January 13, 2022

Site: Juan Tabo Hills Estates (Pulte) – 1900 Duke City St. NE; M21E018_P; NMR1001Z7

Re: Drainage Ordinance (14-5-2-11) Violations for Erosion and Sediment Control

BMP MAP LEGEND

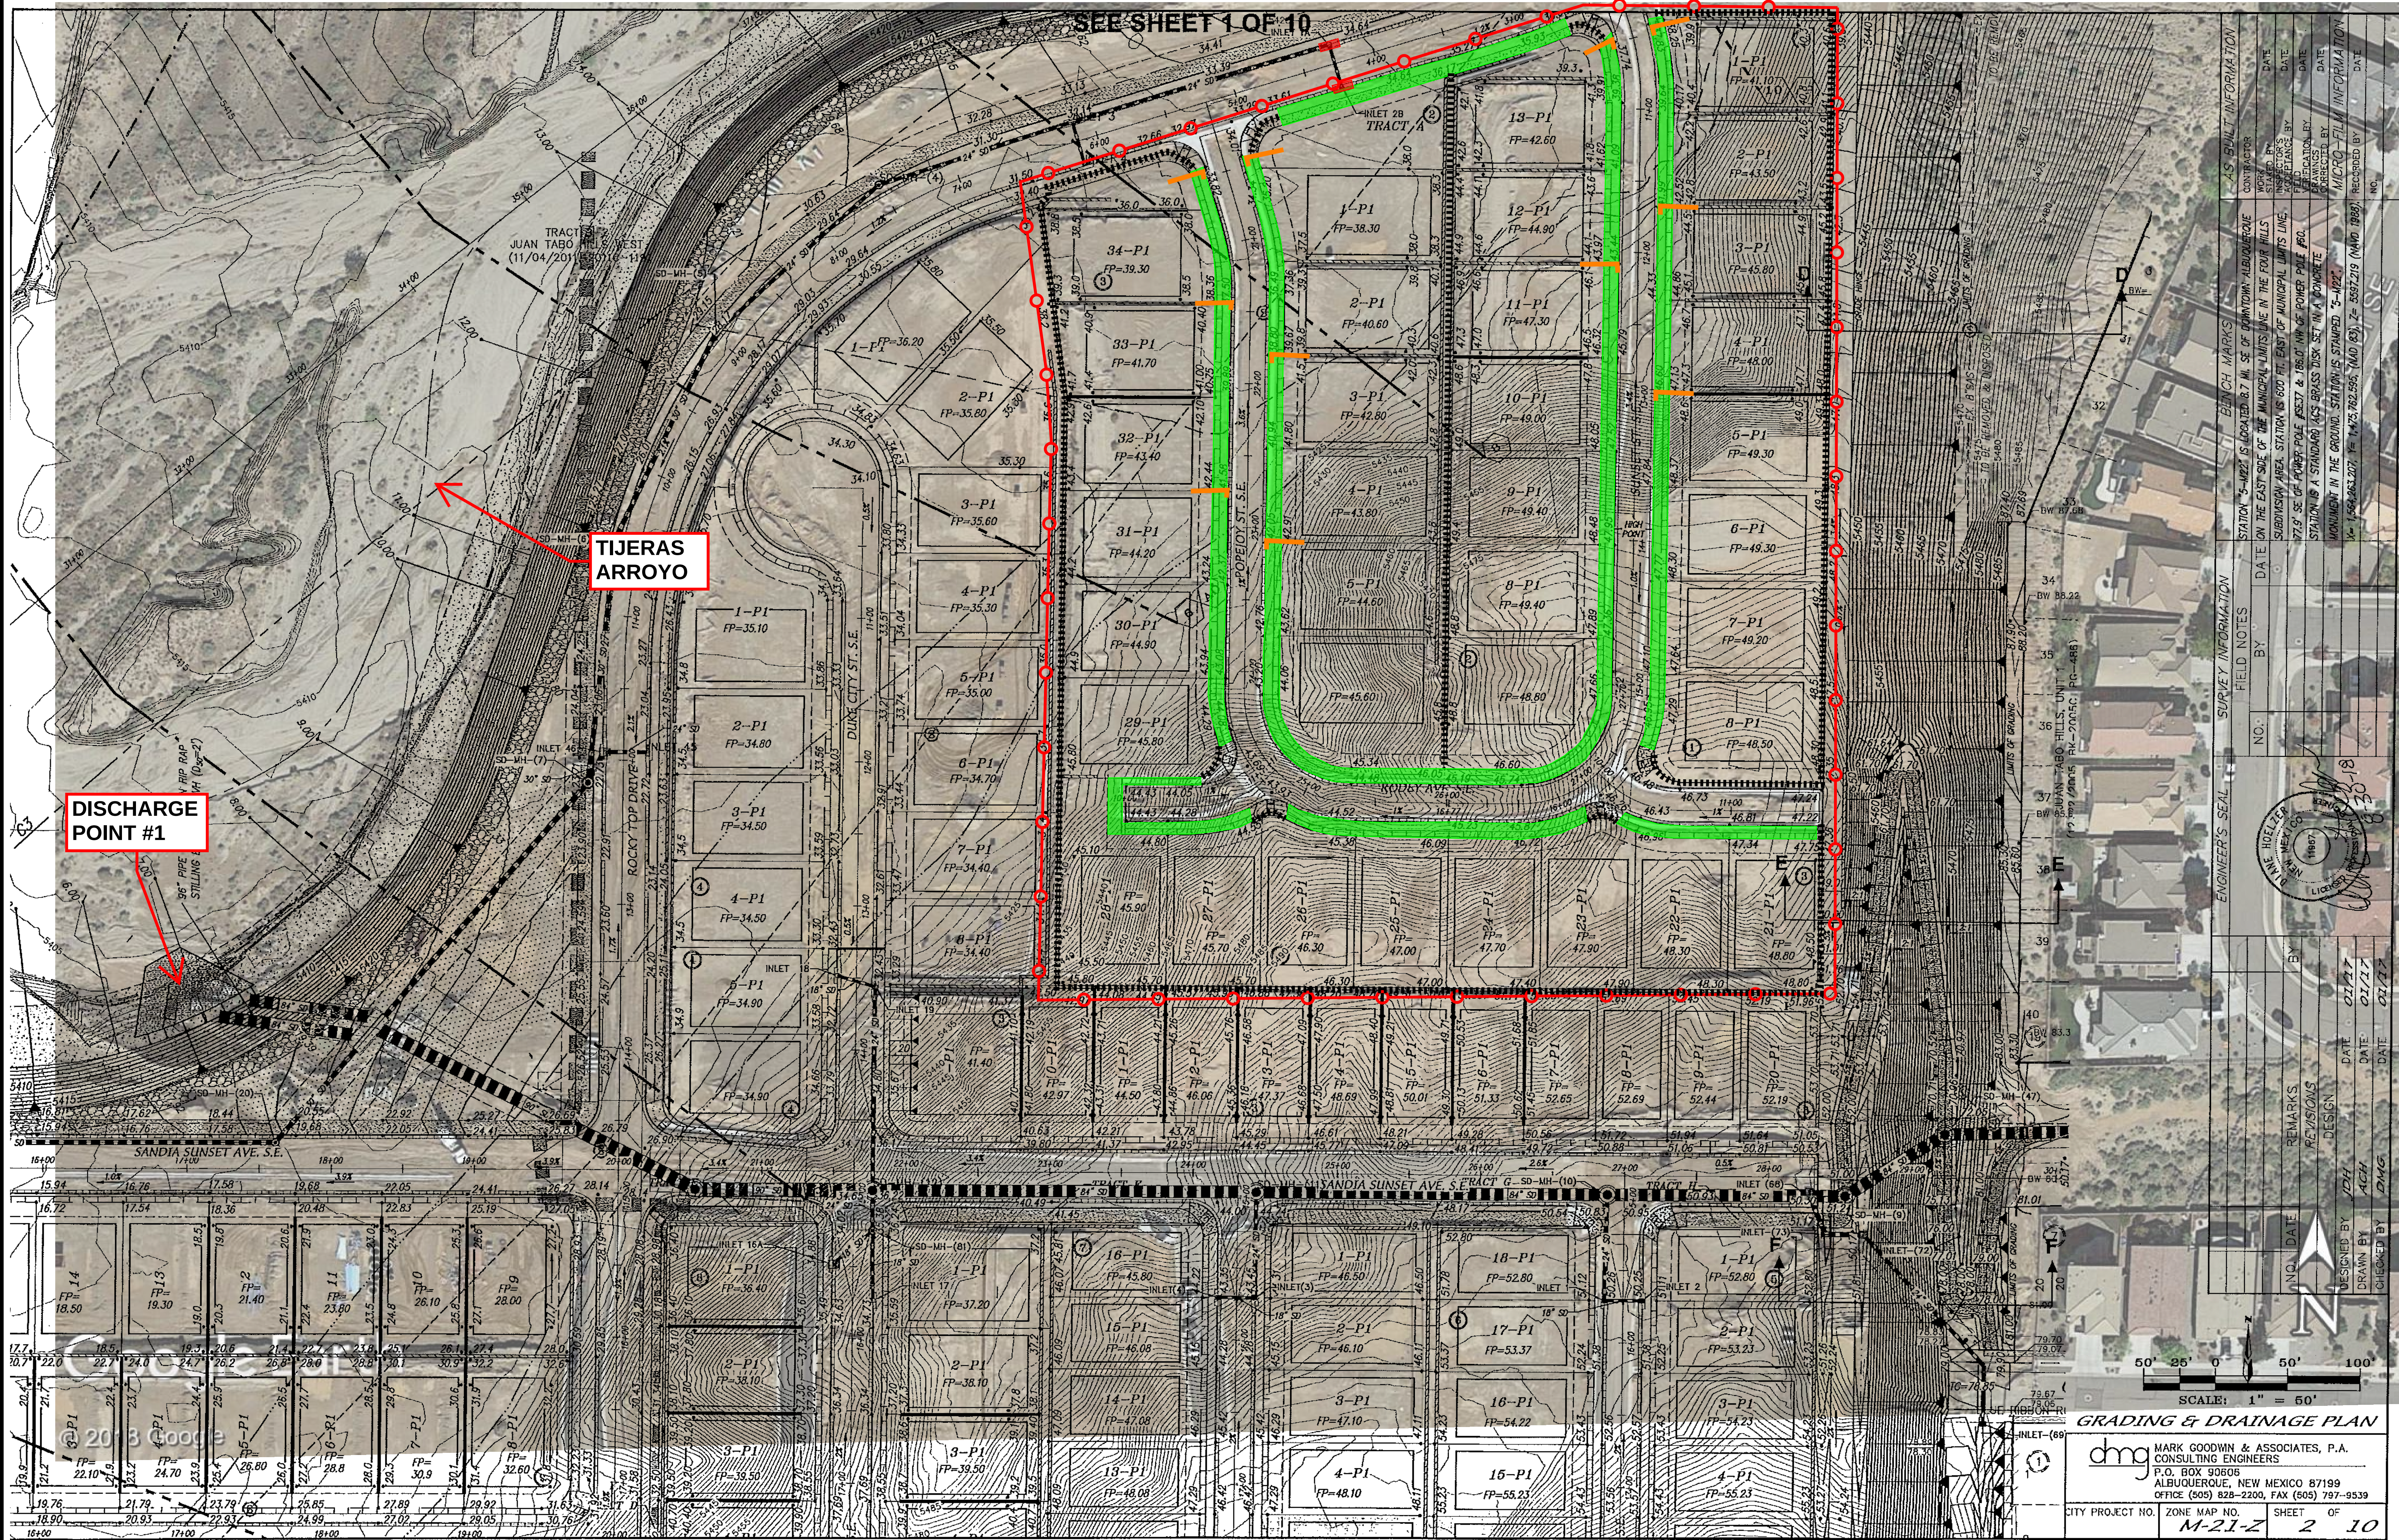
During an inspection on 11/19/2021 the SWPPP was not available onsite, and then during an inspection on 1/12/2022 the SWPPP was not up-to-date. The operator signature was missing, the delegation of authority was blank, the inspection reports weren't signed by the operator, and the SWPPP map had never been updated. (Violation Notification #1)

The SWPPP must be kept up-to-date and available onsite per CGP Part 7.1. If an on-site location is unavailable to keep the SWPPP when no personnel are present, notice of the plan's location must be posted near the main entrance of your construction site CGP Part 7.3.
